Your ref: SSD-79316759
Our ref: DOC25/275573

2 May 2025

Subject: Environmental Impact Statement – Concept Proposal for Mixed Use with Affordable Housing – 45-53 Macleay Street, Potts Point (SSD-79316759)

CPHR advice on EIS – Concept Proposal for Mixed Use with Affordable Housing – 45-53 Macleay Street, Potts Point (SSD-79316759)

45-53 Macleay Street, Potts Point
10% AEP Peak Flood Impact

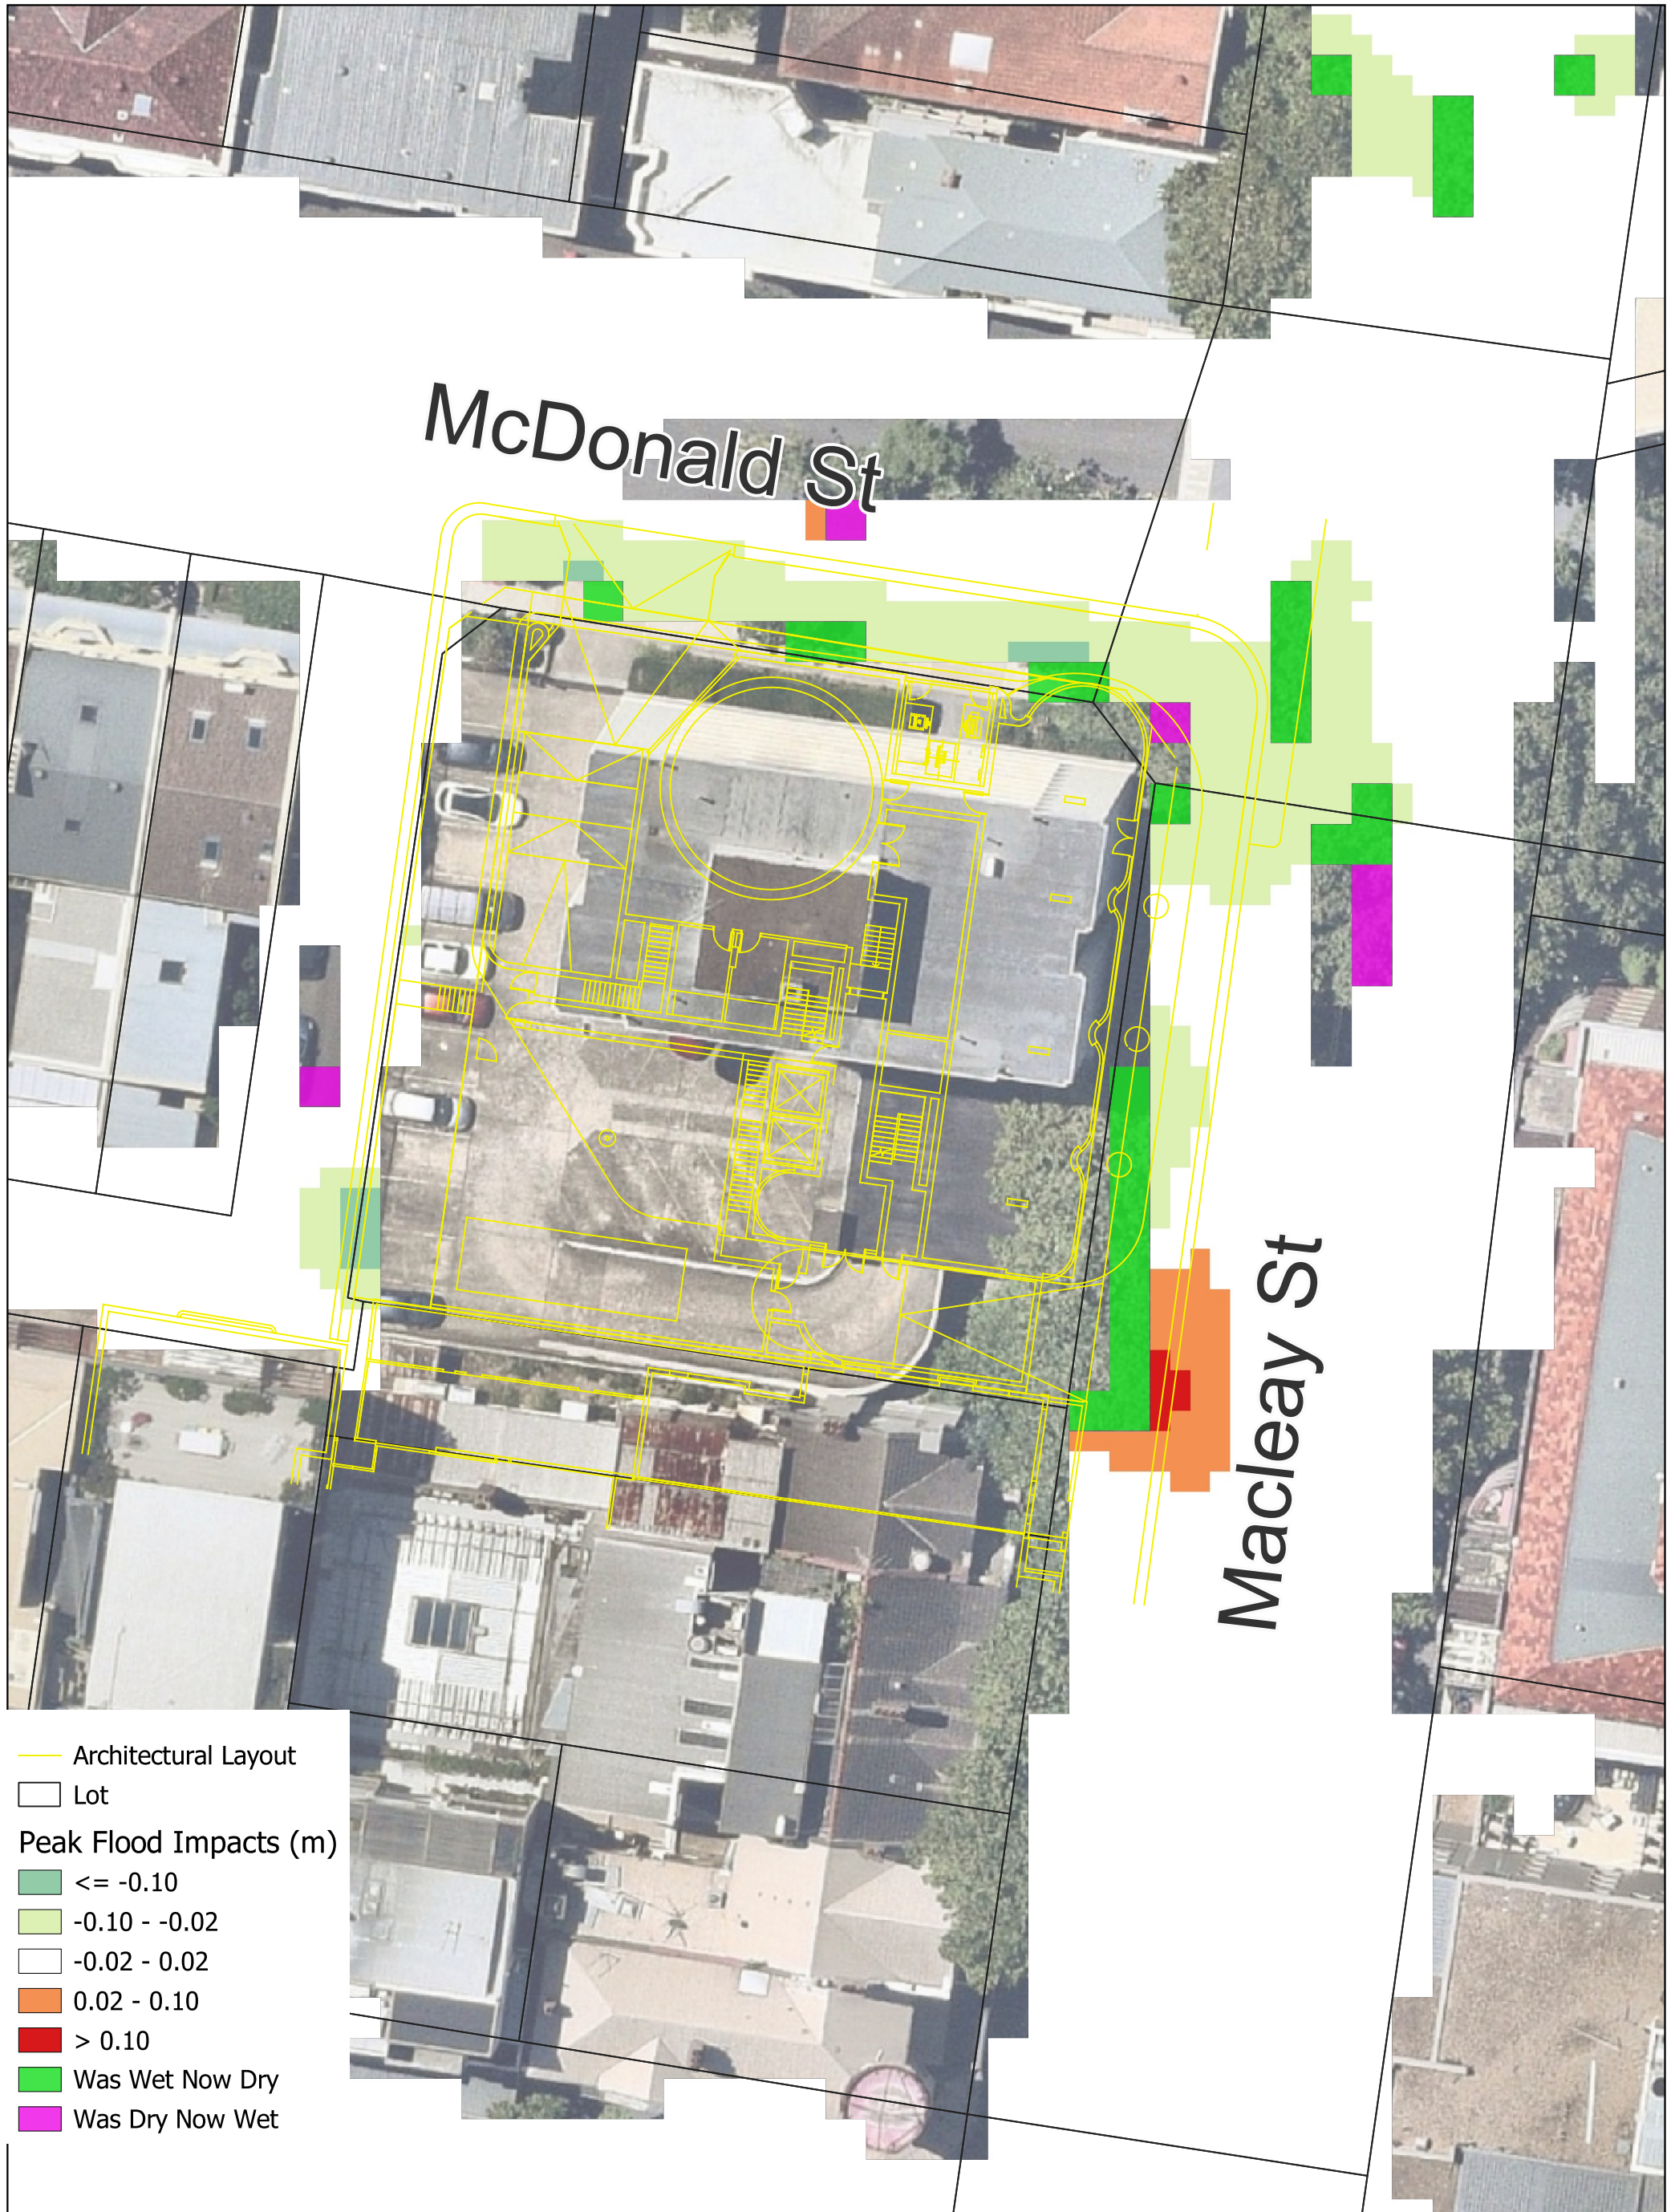
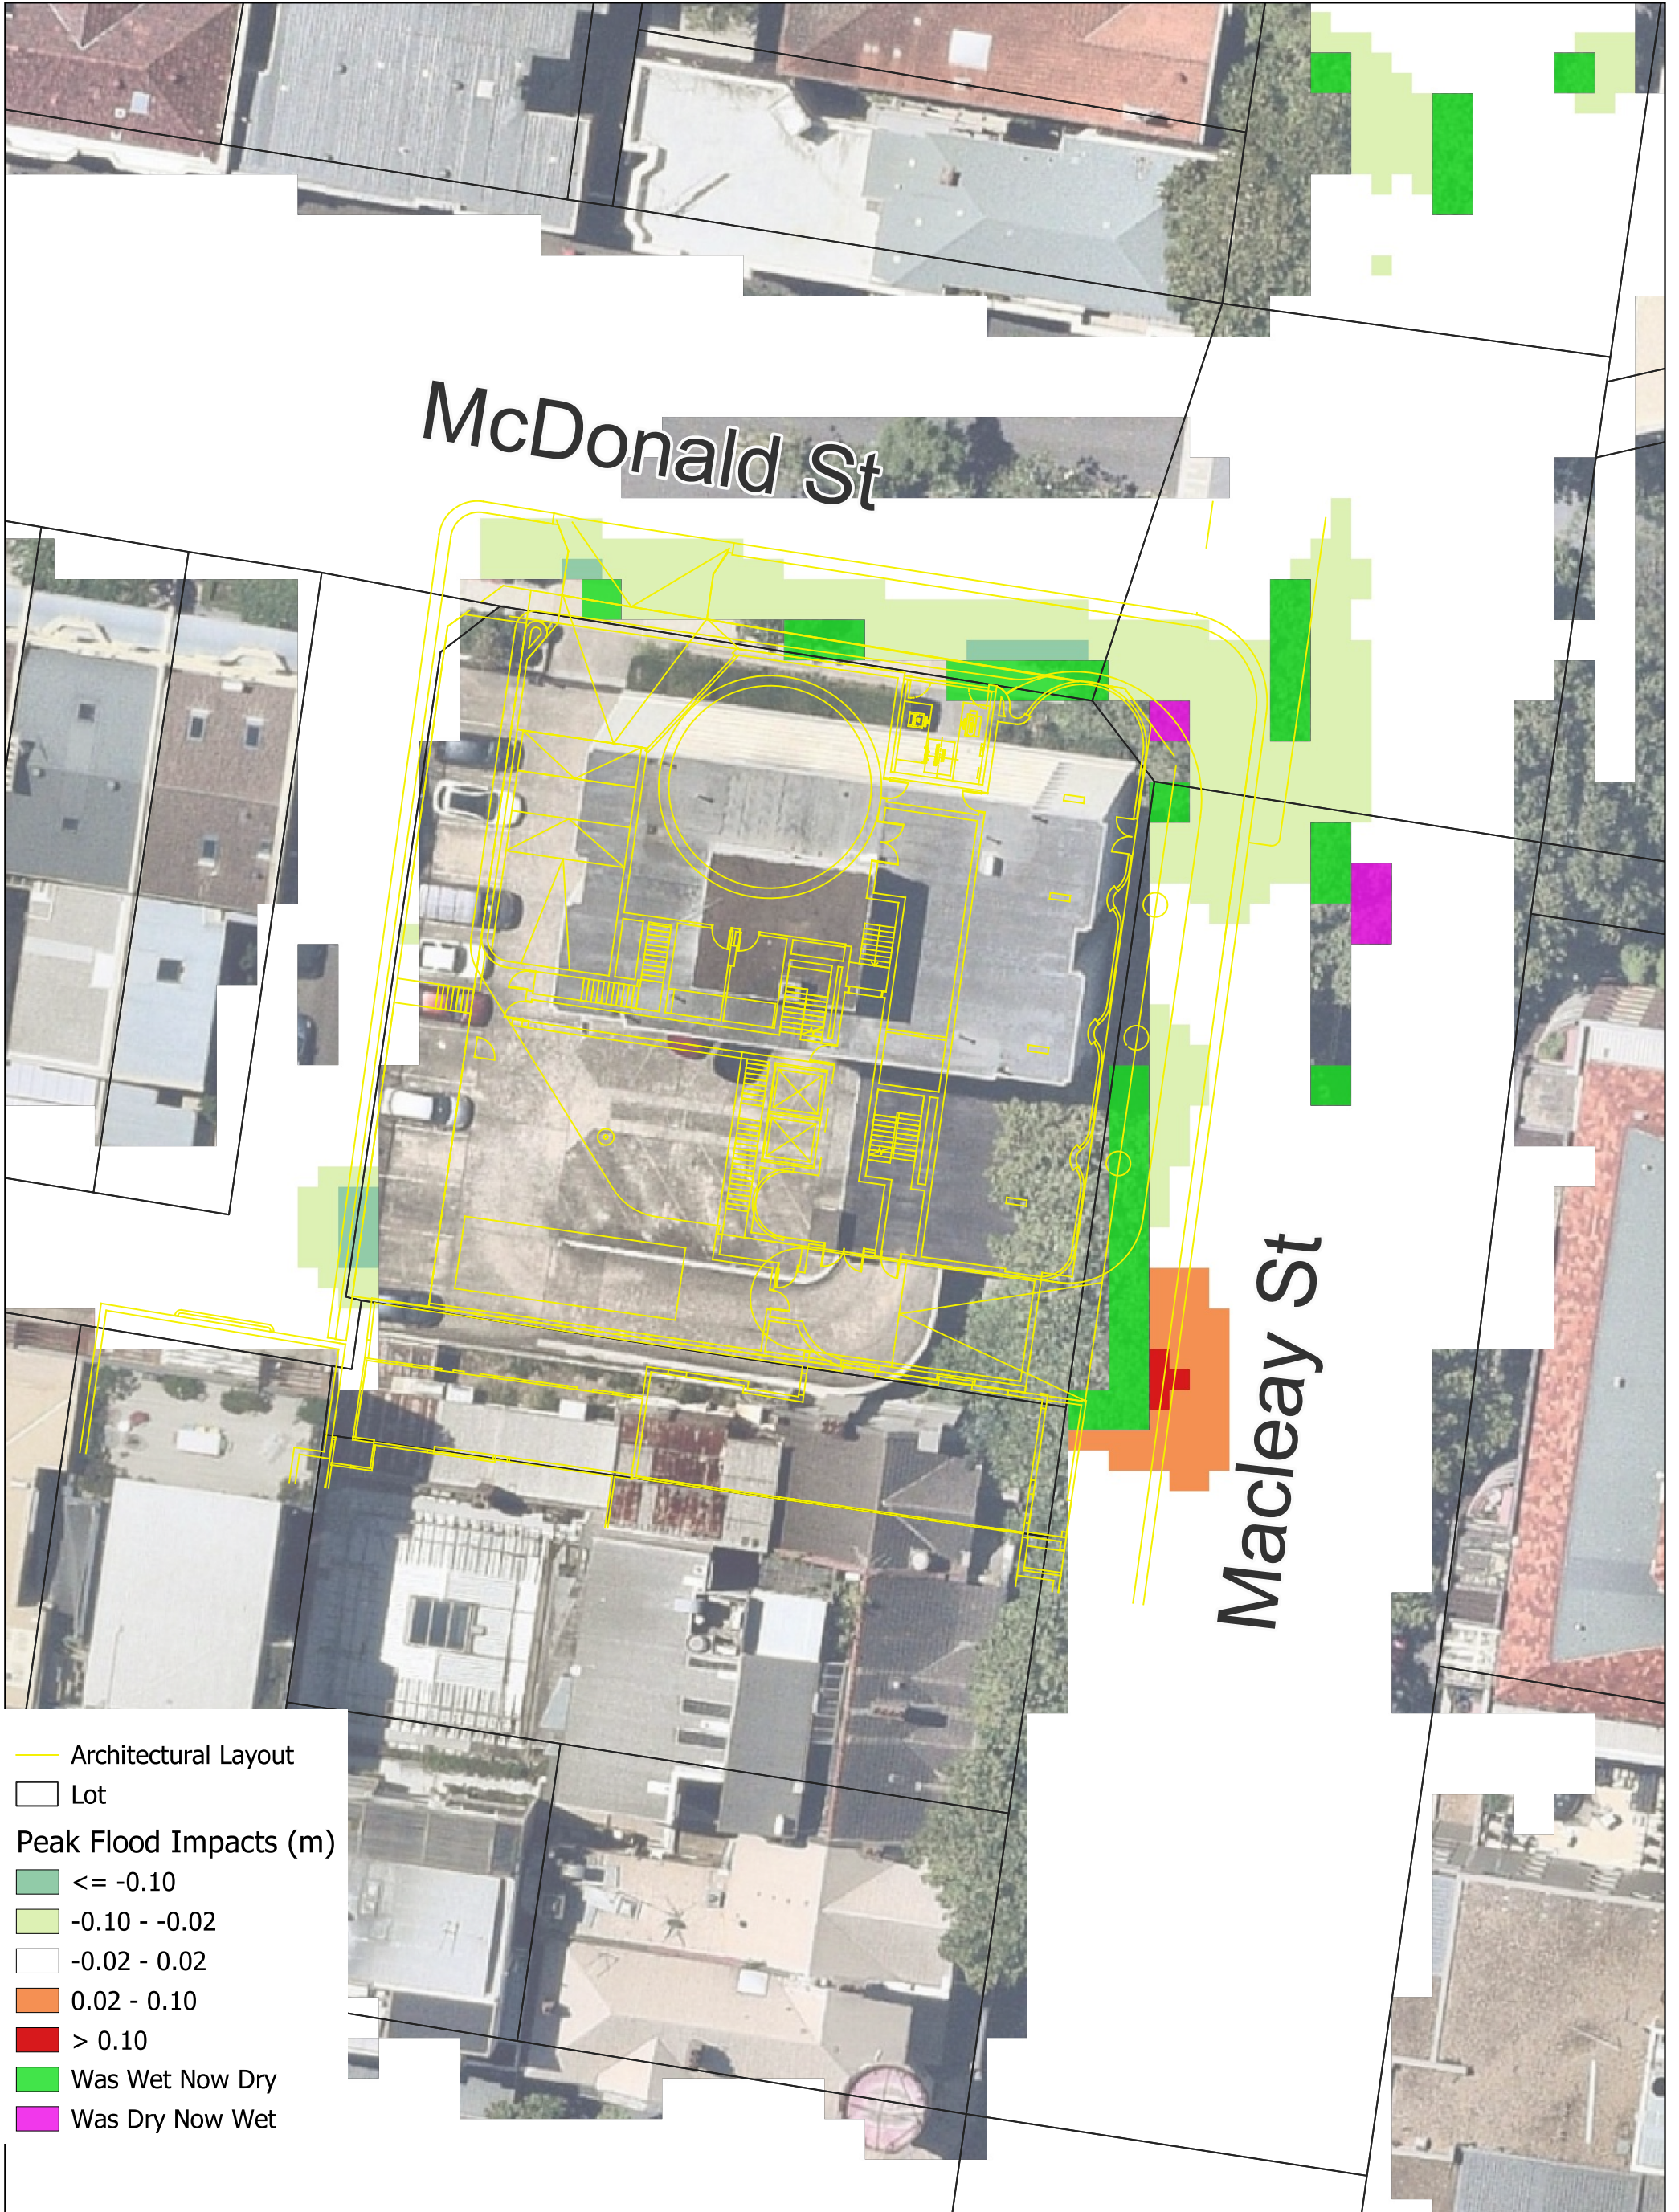
1.	<i>Flood levels in Macleay Street exceed recommended increases</i>	<p>The FIRA indicates that the post-construction flood level will increase by approximately 100 mm in a small section of kerb area in Macleay Street. This increase is attributed to changes in the footpath profile to meet Council's required footpath and flood planning levels for the development. CPHR considers that this impact could be mitigated by appropriate tie-in works to the existing footpath across the front of the adjoining property.</p> <p>Recommended action:</p> <ol style="list-style-type: none"> 1. The conditions of consent include a requirement for tie-in works between the proposed raised footpath and the existing footpath on Macleay Street to minimise increases in the roadway's flood level.
	<i>Extent and Timing</i>	Determination during detailed design.
